Application No: FG/105/20/PL
Site Address: The Tudor Close Public House Ferringham Lane Ferring BN12 5NQ
Description of works: Conversion of existing Public House (Use Class A4) to create 7 No residential units comprising 5 No 1-bedroom units & 2 No 2-bedroom units & the erection of 2 No 1-bedroom semi-detached bungalows, associated car parking & landscaping (resubmission following FG/46/20/PL). This application affects a Public Right of Way & is in CIL Zone 4, CIL Liable for new dwellings.

Thank you for your internet representation made on 23rd September 2020 which has been recorded as an objection with the comments as follows:

OWPC29811

Proposed Landscaping Plan

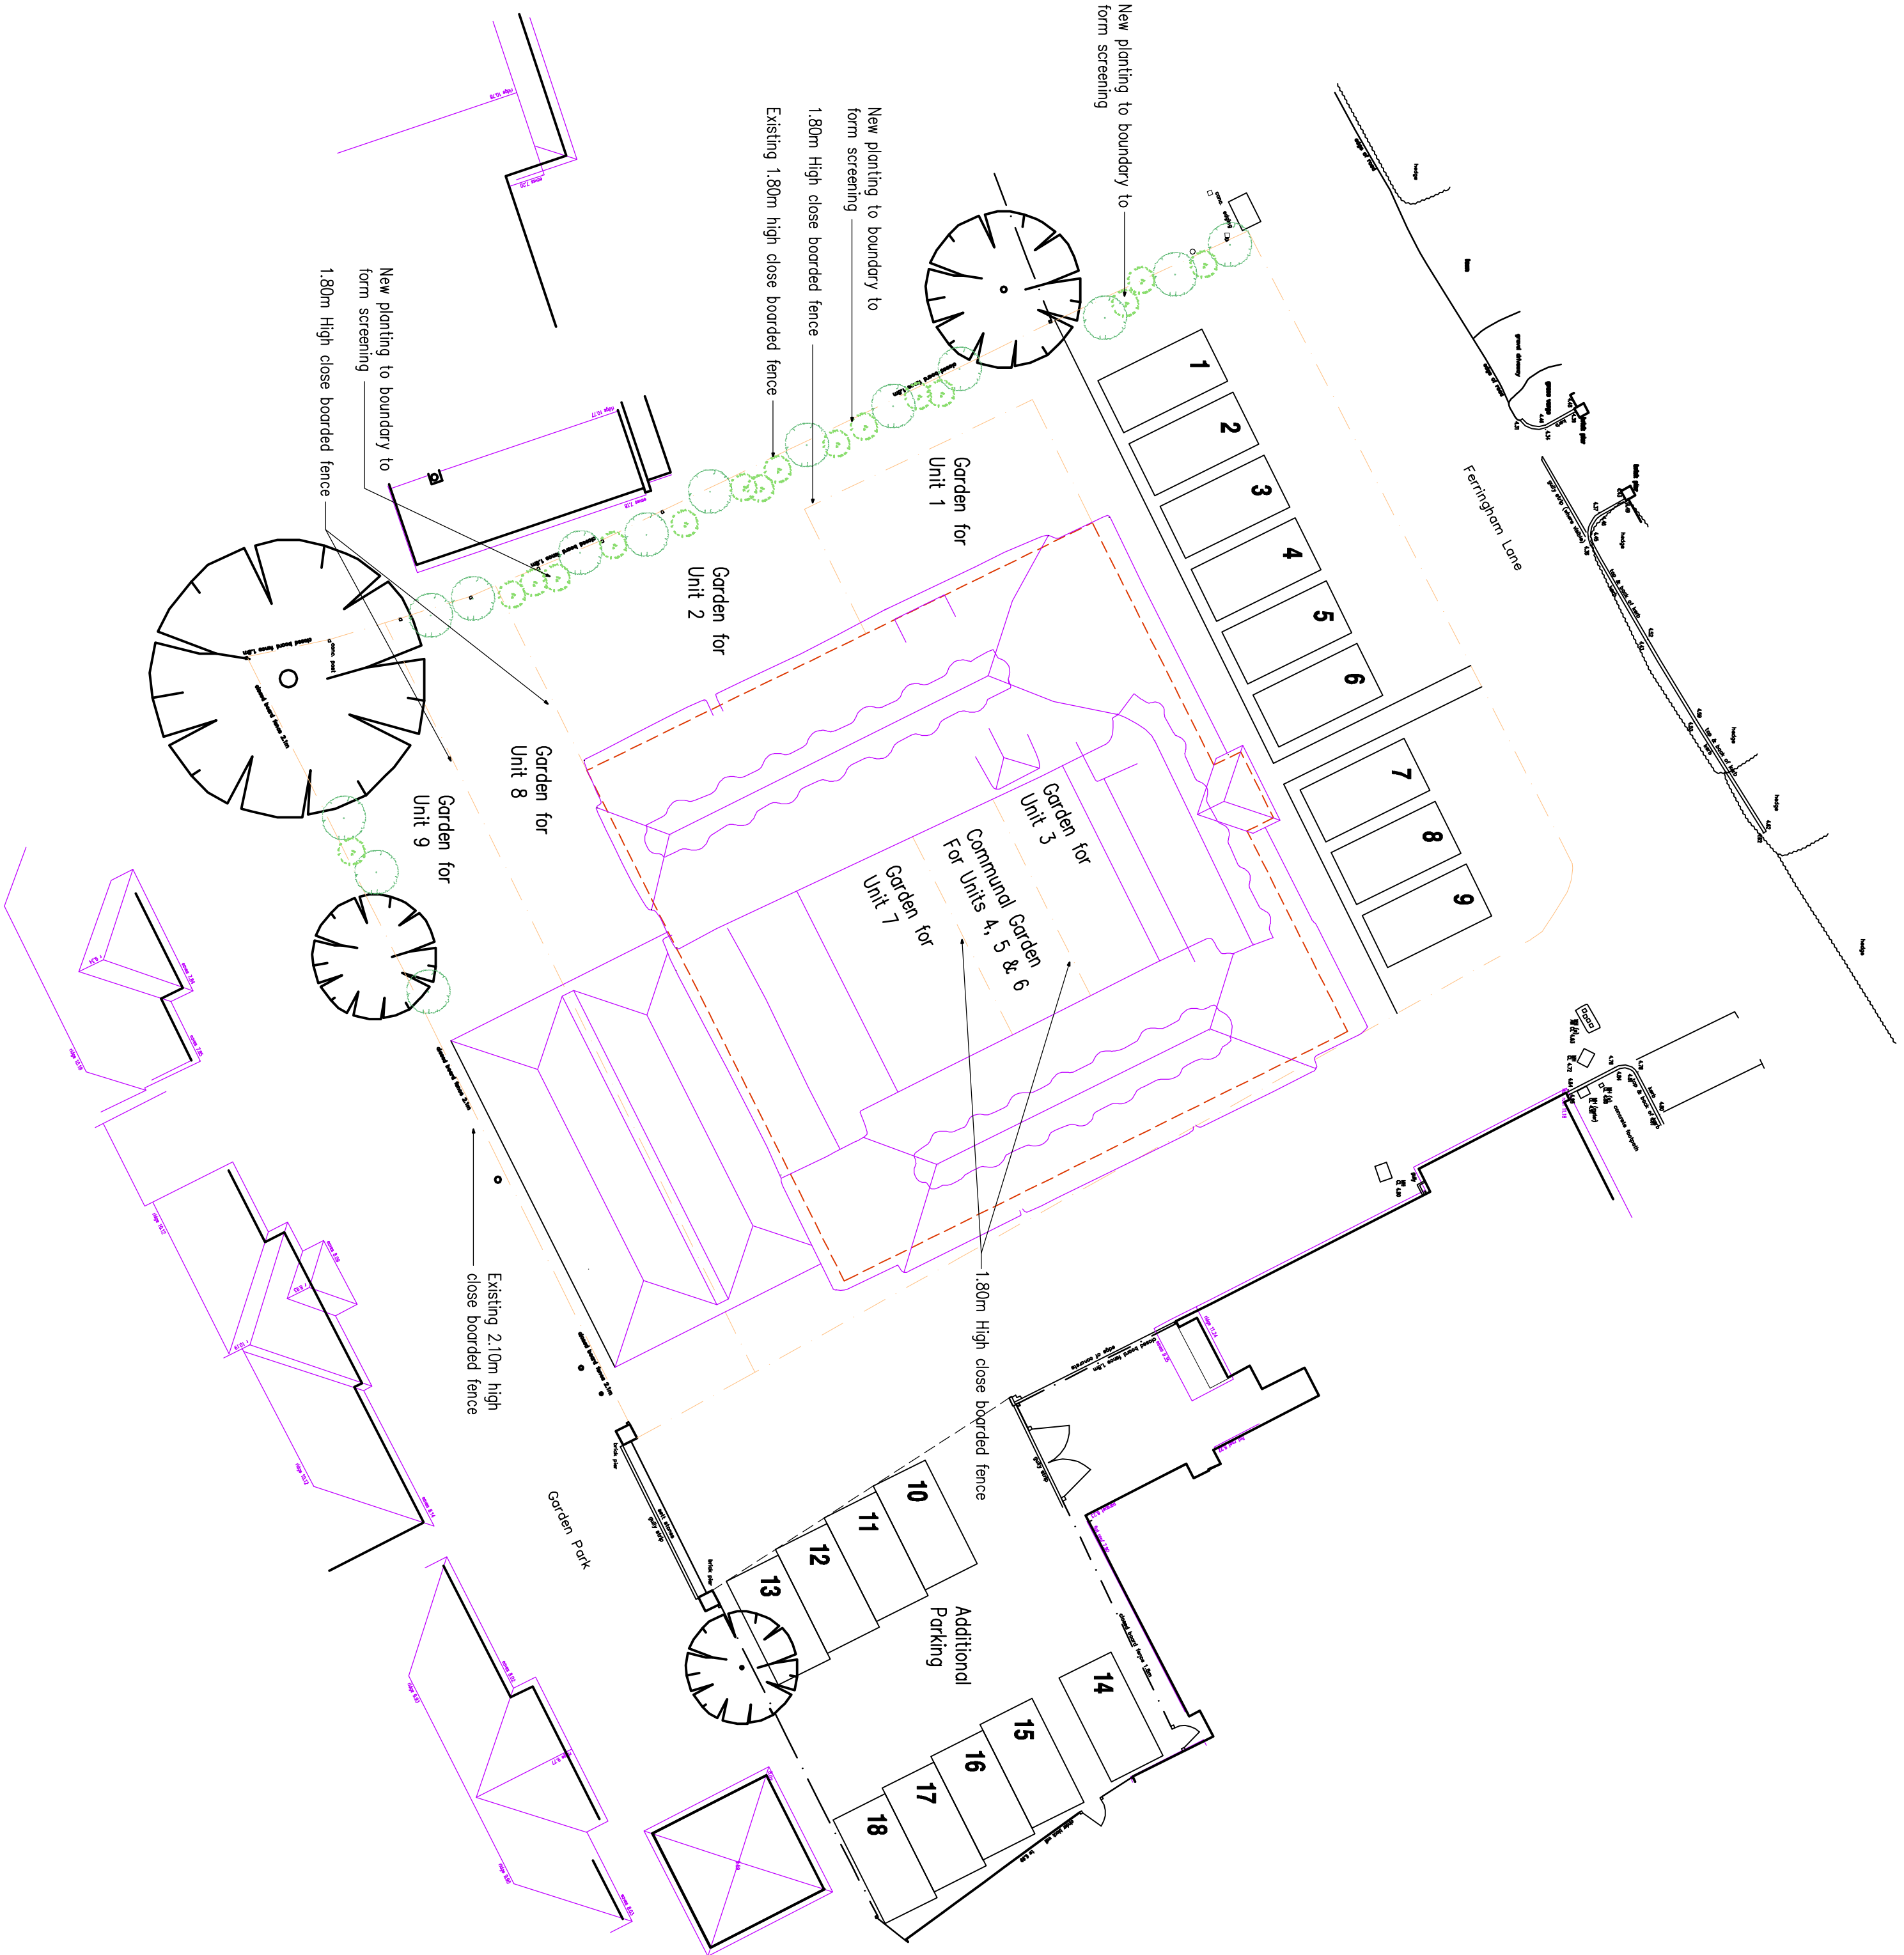
I also note that the existing site plan shows the established trees along the site boundary yet the plans as submitted do not show the trees as per the existing plan. Yet again the application form makes no reference as to trees to be removed. I would therefore suggest that as the forms have not been completed correctly and that the proposed plans show trees omitted or removed from land out with the application site, which is wholly out with the applicant's control. The application in its present form should be declared invalid.

Should consideration be given to approving this application in its present form. It should be strictly conditioned to ensure appropriate materials etc are used and the scale of the proposal is in accordance with the suitable space available and that provision is made to protect the boundary fence line and trees which are out with the application site but would be adversely effected by a development in such close proximity to the boundary.
